Submissions Report

*SSD-87486461
20-22 Atchison Street, St
Leonards*

This Response to Submissions Report (**Submissions Report**) has been prepared on behalf of Setia Sydney Pty Ltd (the **Applicant**) in relation to State Significant Development Application (**SSDA**) 87486461 for the residential development at 20-22 Atchinson Street St Leonards (the **site**). This report has been prepared to address the matters raised by public agencies, local Council, the community and other relevant stakeholders throughout the public exhibition period.

SETIA SYDNEY PTY LTD
 PROPOSED MIXED-USE DEVELOPMENT
 20-22 ATCHISON STREET
 ST LEONARDS
 SWEPT PATH DIAGRAM

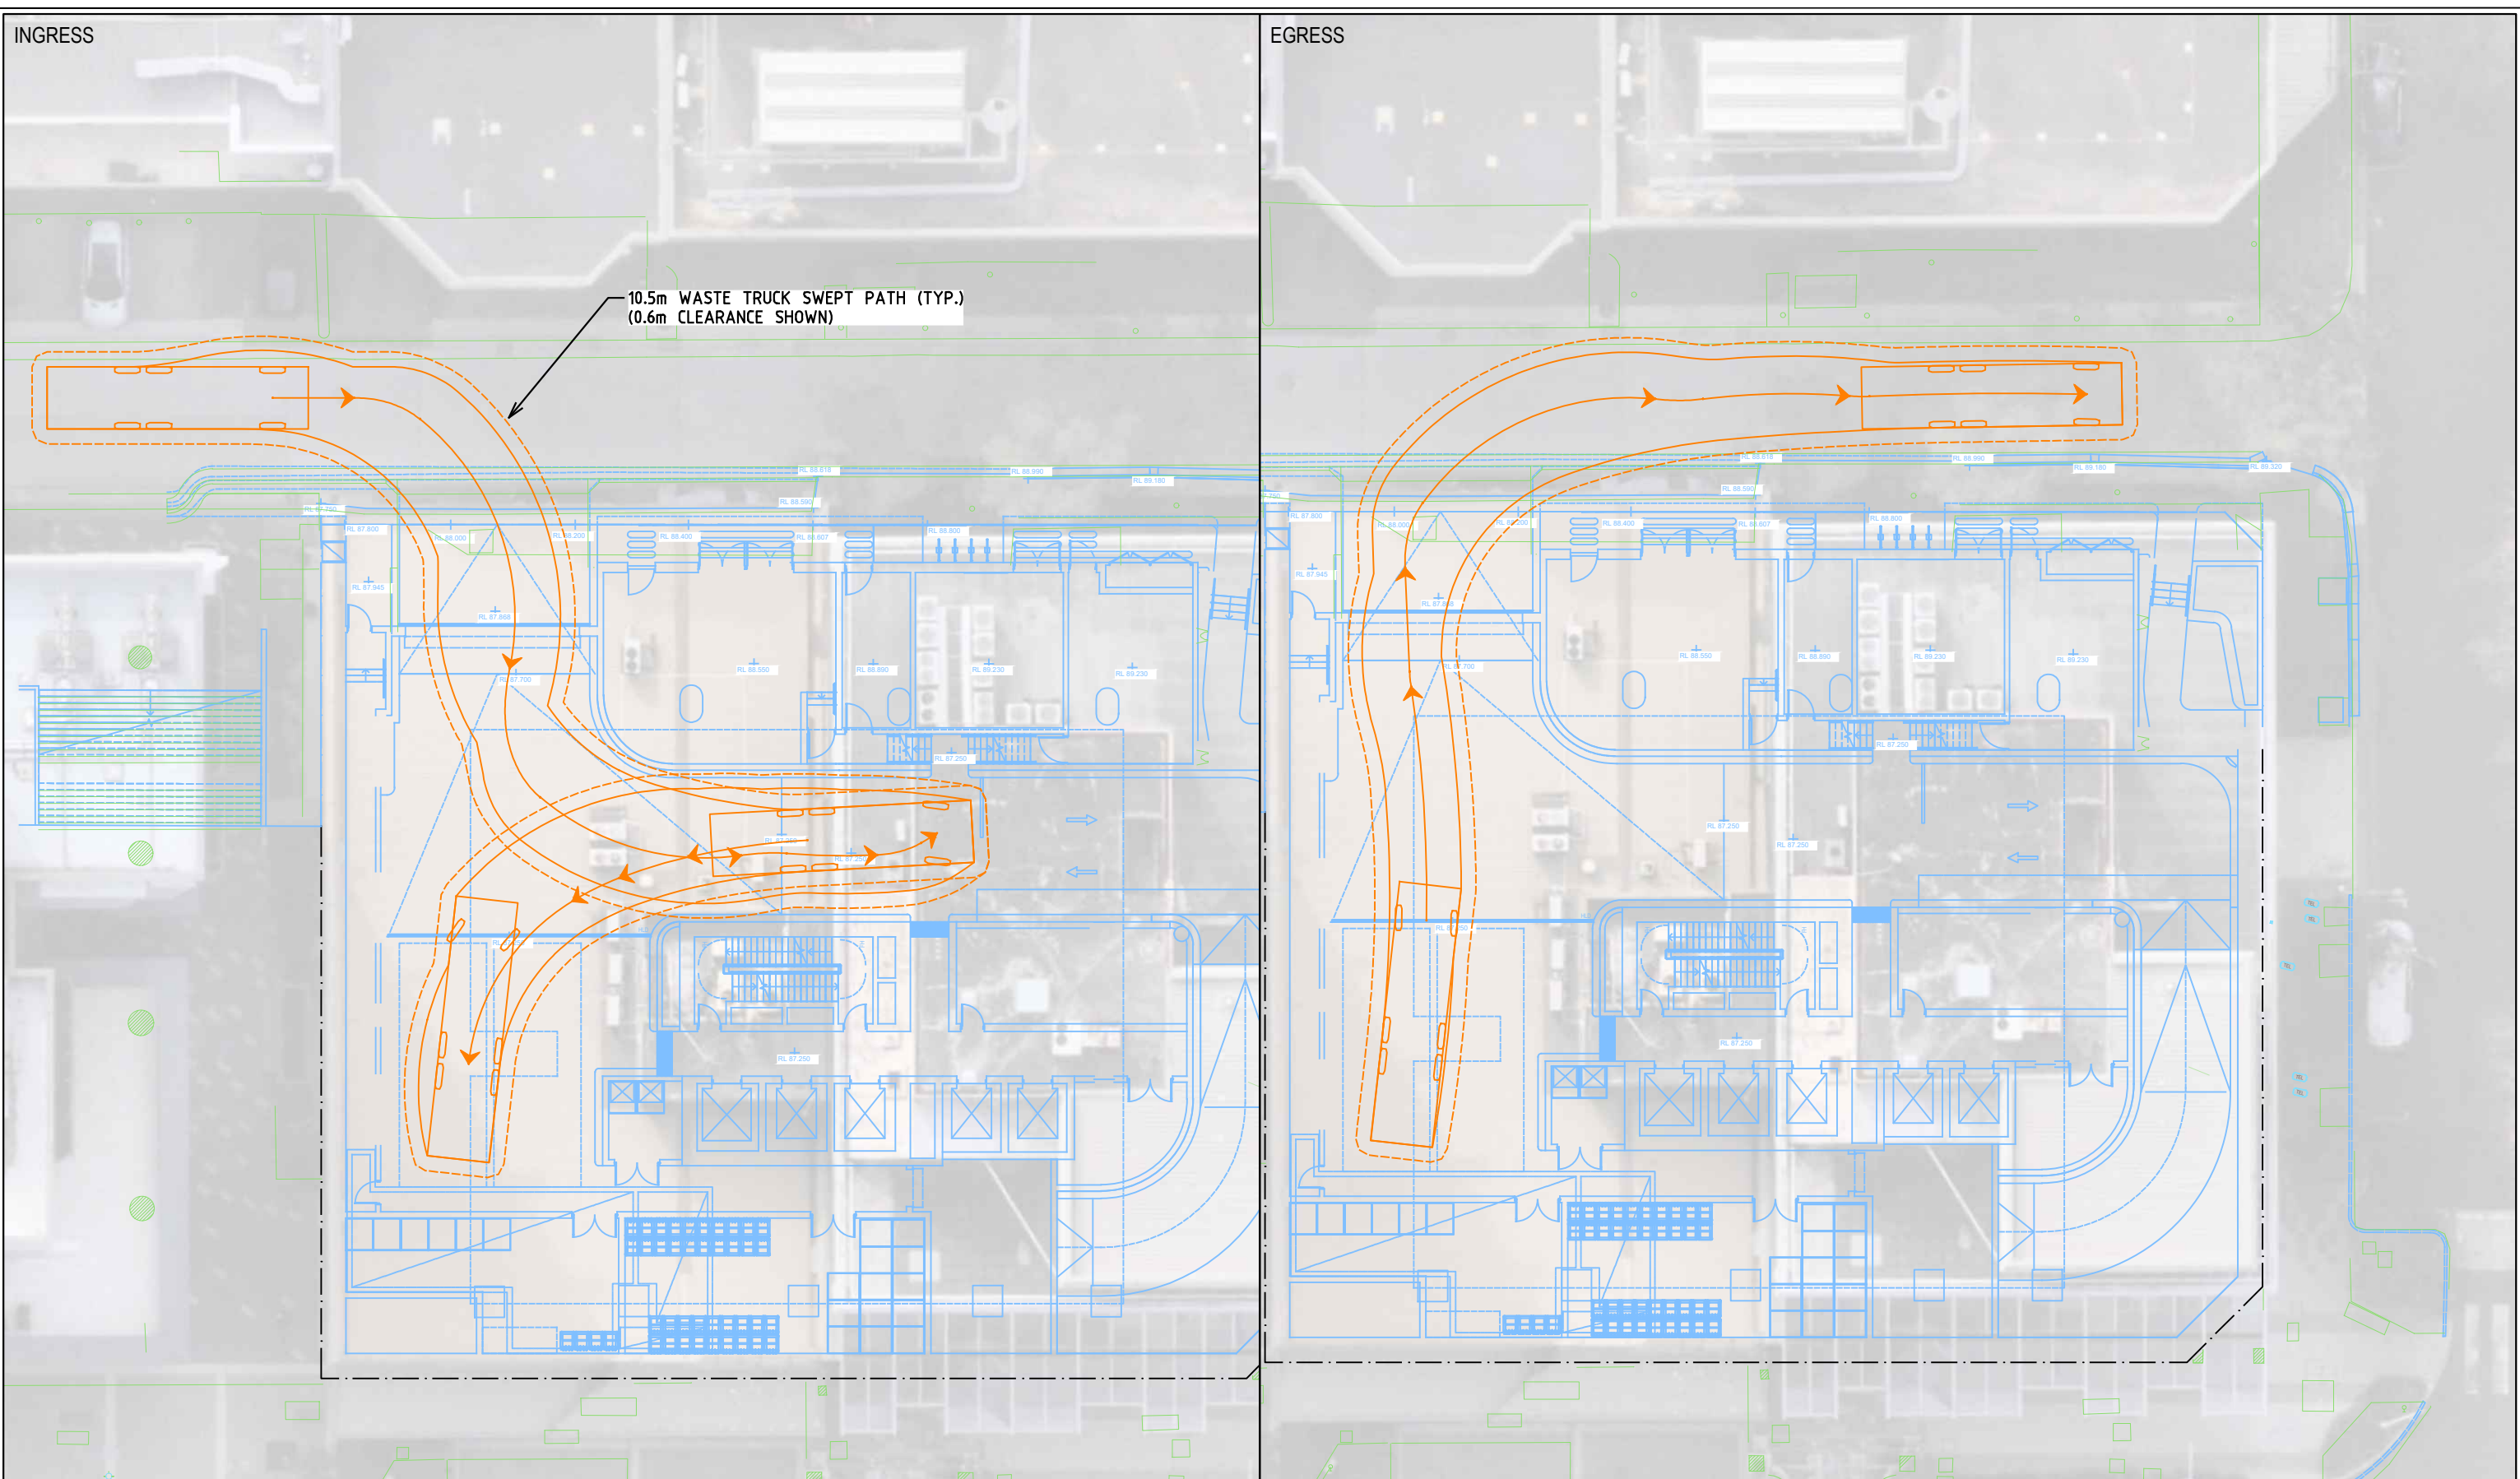
<p><i>d) Confirm that the development has been designed to enable on-site waste collection by Council's waste collection fleet, including adequate access and manoeuvring space.</i></p>	<p>An updated Waste Management Plan has been prepared by Salt3.</p> <p>In summary the WMP provides a waste truck swept path using the specifications of the collection vehicle used by Council's contractors and indicates the truck can enter and exit the site without hitting any objects, which, in the waste consultant's expert opinion, indicates a satisfactory waste collection arrangement. It is further noted that a 600mm clearance has been adopted for the swept path assessment, which is double the minimum required by AS2890.2 of</p>

- Email from SALT to North Sydney Council on Wednesday 25 February 2026 providing swept path analysis of the truck entering the site from the west, which does not require a corrective movement to enter the loading bay. Also advising that a temporary holding bay at Atchison Lane would not be feasible due to the location of services infrastructure that cannot be moved.

- Email from SALT to North Sydney Council on Tuesday 3 March 2026 advising that the clearance shown on swept paths is 600mm and also providing an exit swept path for the collection vehicle.

- Email from North Sydney Council to SALT on Thursday 12 March 2026 confirming that the proposed plan was acceptable to Council.

Tower Typical Plan Level 30-38
1:200

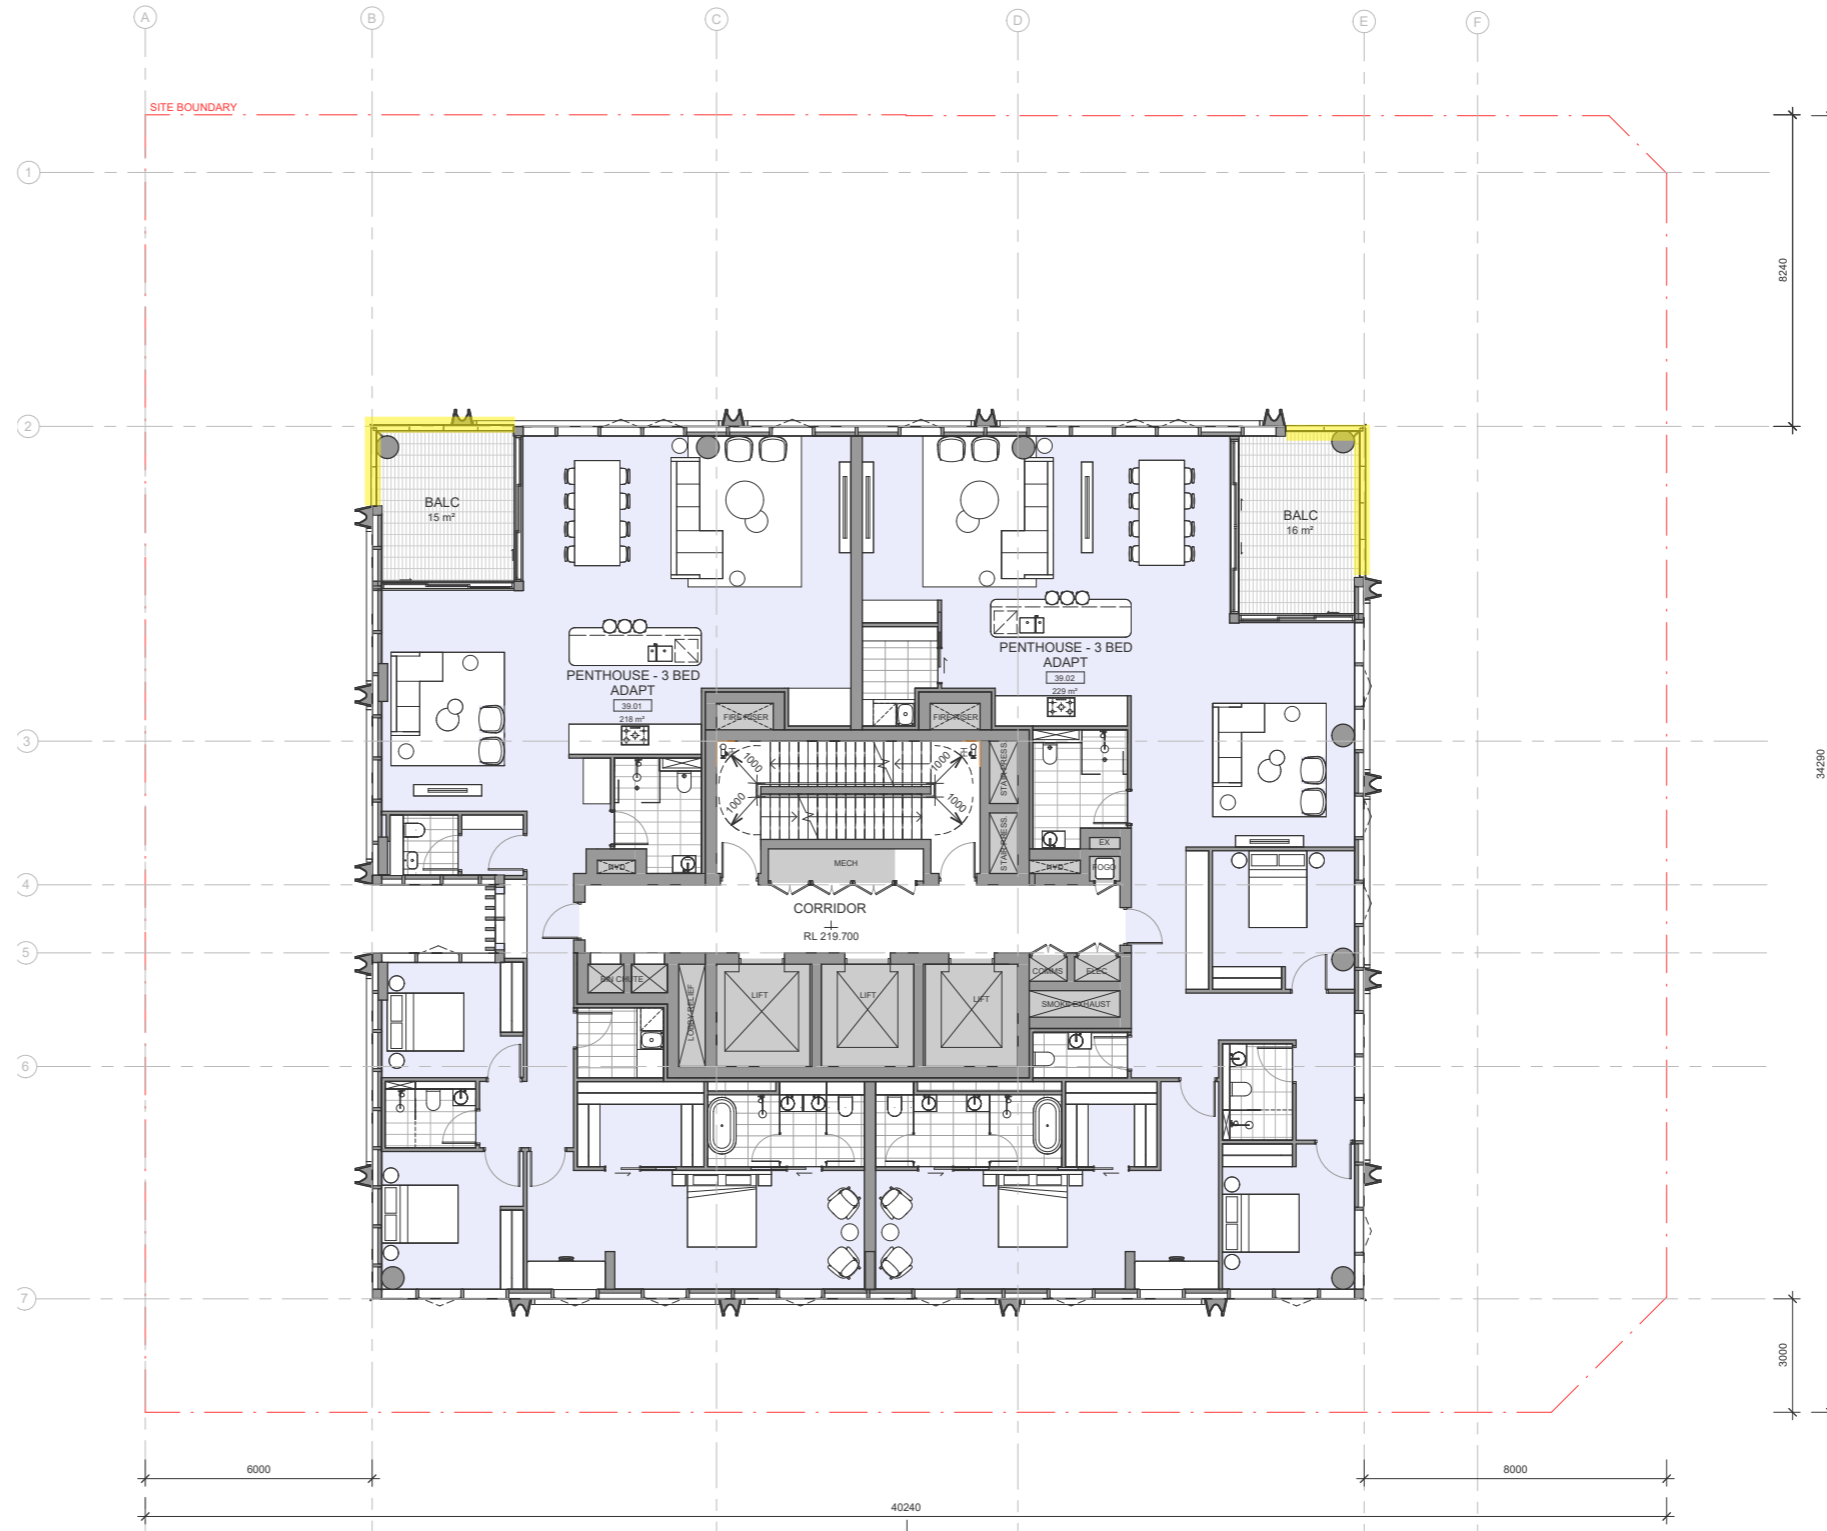
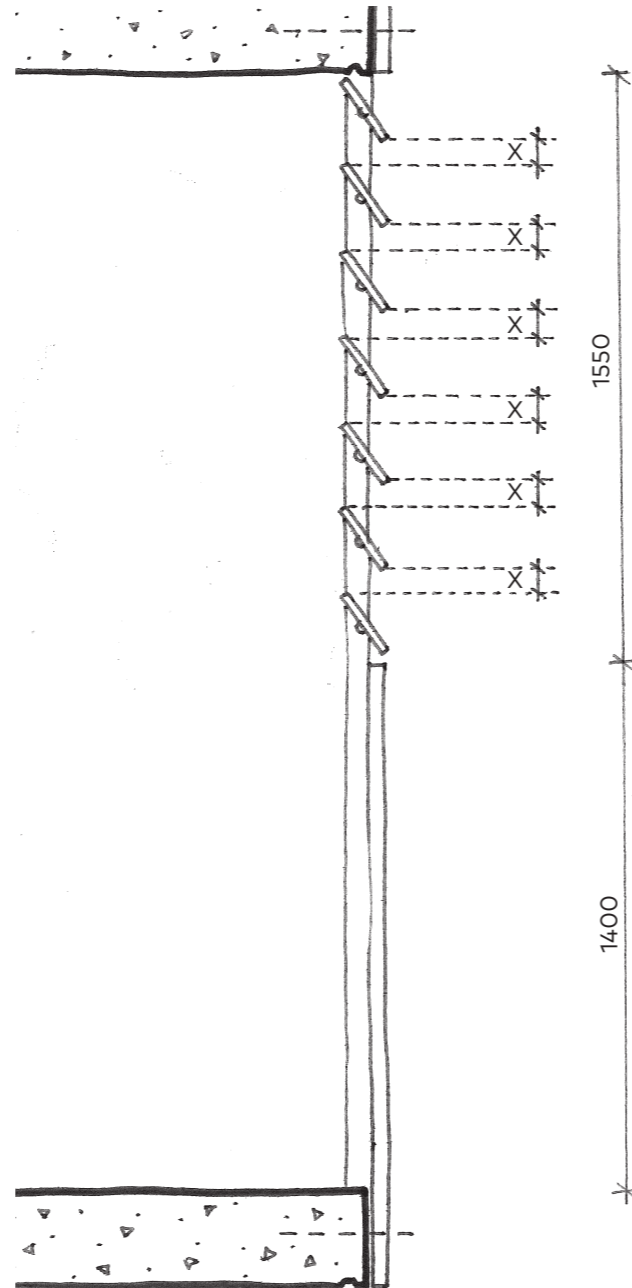
Key Issue	Description	Response	Refer to
1. Gross Floor Area	<i>The fixed glass louvres included throughout the residential levels of the building allow for fully enclosed balconies and are therefore considered residential gross floor area (GFA) in accordance with the North Sydney Local Environmental Plan 2013. The balcony balustrades on Levels 2 and 3 also exceed 1.4 metres in height, potentially contributing to additional GFA. The total GFA of the development must be confirmed taking into account these matters. Any exceedance of the maximum floor space ratio (FSR) control for the site must be addressed in a clause 4.6 variation request.</i>	<p>To minimise the amount of fully enclosed balconies, the following changes are proposed:</p> <ul style="list-style-type: none"> ▪ Levels 2 and 3: 1100mm glass balustrade. ▪ Levels 6-14: contain primarily a 1400mm glass balustrade, with fixed louvres in certain positions. ▪ Levels 15-29: majority contain fixed louvres; however a 1400 glass balustrade is provided in certain positions. ▪ Levels 30-39: majority contain fixed louvres, however some on the southwest corner contain operable louvres. <p>The fixed louvres proposed are not fully enclosed with 30% openings. Therefore, the GFA on these balconies has not been incorporated into the total GFA calculation.</p> <p>As a result, the total GFA proposed is 18,961sqm with an FSR of 13.82:1.</p>	Appendix D Appendix K Appendix L

Figure 7 and Figure 8, (read with the legend at Figure 6) illustrate the updated balcony design across the development. The proposal introduces a modified approach with different balustrades and louvres proposed on different level sections, responding to the wind exposure identified in Appendix D (Wind Impact Assessment) . These changes are justified further in Section 4.1.

- **Podium typical Plan Level 2&3:** solid balustrade
- **Tower typical plan level 6-14:** glass balustrade and glass balustrade with fixed louvres above
- **Tower typical plan level 15-29:** glass balustrade and glass balustrade with fixed louvres above
 - Note levels 15-29 contain more fixed louvres than levels 6-14 in response to the wind report.
- **Tower typical plan level 30-38:** glass balustrade, glass balustrade with fixed louvres above and glass balustrade with operable louvres above
 - The south-western is entirely enclosed in response to the wind report.
- **Tower Plan Level 39:** glass balustrade with fixed louvres above
 - This level contains entirely enclosed balconies which results

It is important to note that fully enclosed balconies on levels 30-39 fully are included in the developments GFA calculations.

Ground Floor Cafe Activation Plan
1:100

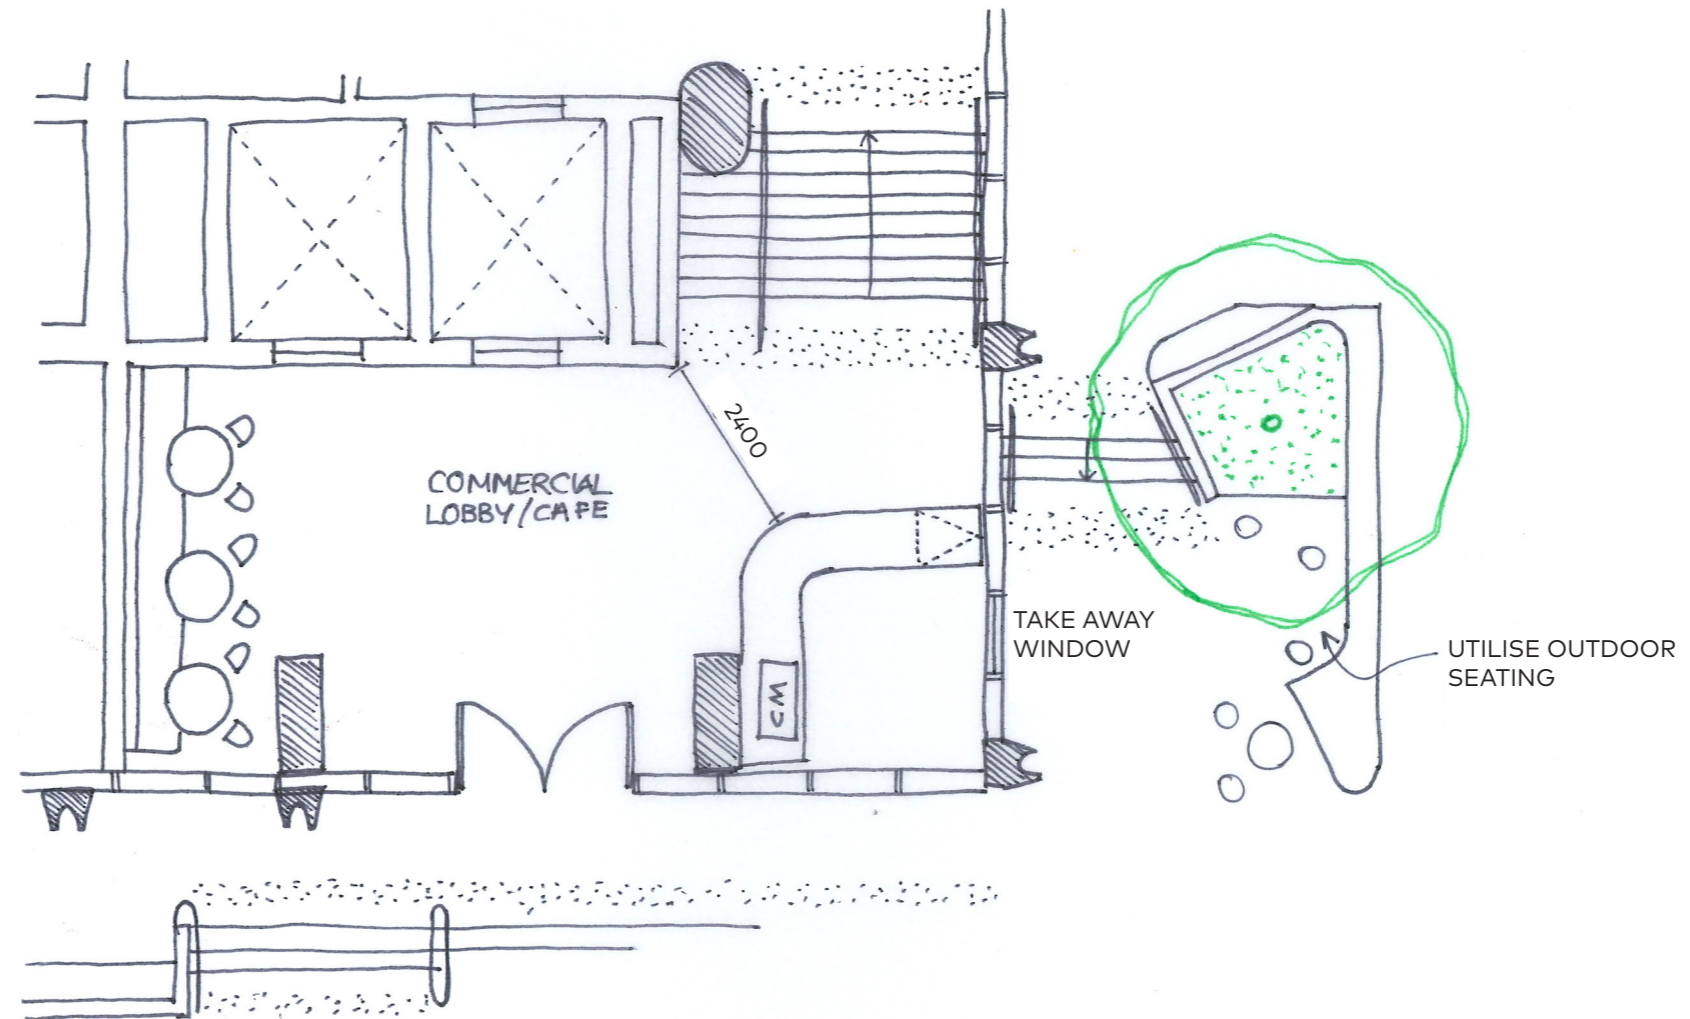
Key Issue	Description	Response	Refer to
Other Issues	<p>a) <i>The proposal involves a significant variation to the non-residential FSR development standard and is a key concern raised by Council. Consider increasing the provision of non-residential FSR to more closely align with the standard.</i></p>	<p>The Economic Analysis prepared by Urbis (September 2025) identifies:</p> <p><i>The commercial office market in St Leonards/Crows Nest is facing significant challenges, with vacancy-rates anticipated to remain above 25% over the next ten years.</i></p> <p><i>Considering the existing stock, planned additions and withdrawals of office floor stock in the area, the market would support a limited amount of commercial floorspace in the podium of the proposed development, of approximately 1,500 sqm in 2028, when the development is due for completion</i></p> <p><i>As of January 2025, the vacancy in the Study Area was 108,927 sq.m (30.5%), the highest for any commercial office market in Sydney, a worrying prospect for owners of buildings located in the Crows Nest/St Leonards office market.</i></p> <p><i>In addition to this, weak absorption levels in Crows Nest/St Leonards continue, as the market has been subdued by competition from newer stock in other office markets and the better located North Sydney and Sydney CBD markets.</i></p> <p>The development proposes 1,938sqm commercial floor space. A further increase in commercial floor space would not be supported by the market as the current and forecast demand does not justify additional supply. Introducing more office floorspace in this context risks long-term vacancy and underperforming assets. Prioritising non-residential uses that support a diverse, active and resilient centre better aligns with contemporary planning objectives and the current housing crisis.</p> <p>The Submissions Report therefore does not seek to increase the non-residential FSR however there is an increase in the diversity of the commercial floor space provided. As outlined previously, a café tenancy is proposed on the ground</p>	Appendix K

- Widening of vehicle crossing to lower ground floor vehicle entrance to accommodate Salt3 updated swept paths, refer to Appendix J (Waste Management Plan) for further details.
- Activation of the Commercial Lobby to the ground floor through the insertion of a café that trades both internally and through a takeaway window adjacent to the Mitchell St Landscaped setback.
 - Refer to Figure 4 for the Ground Floor Activation Plan details.
- Nomination of public art zone to western wall of podium.
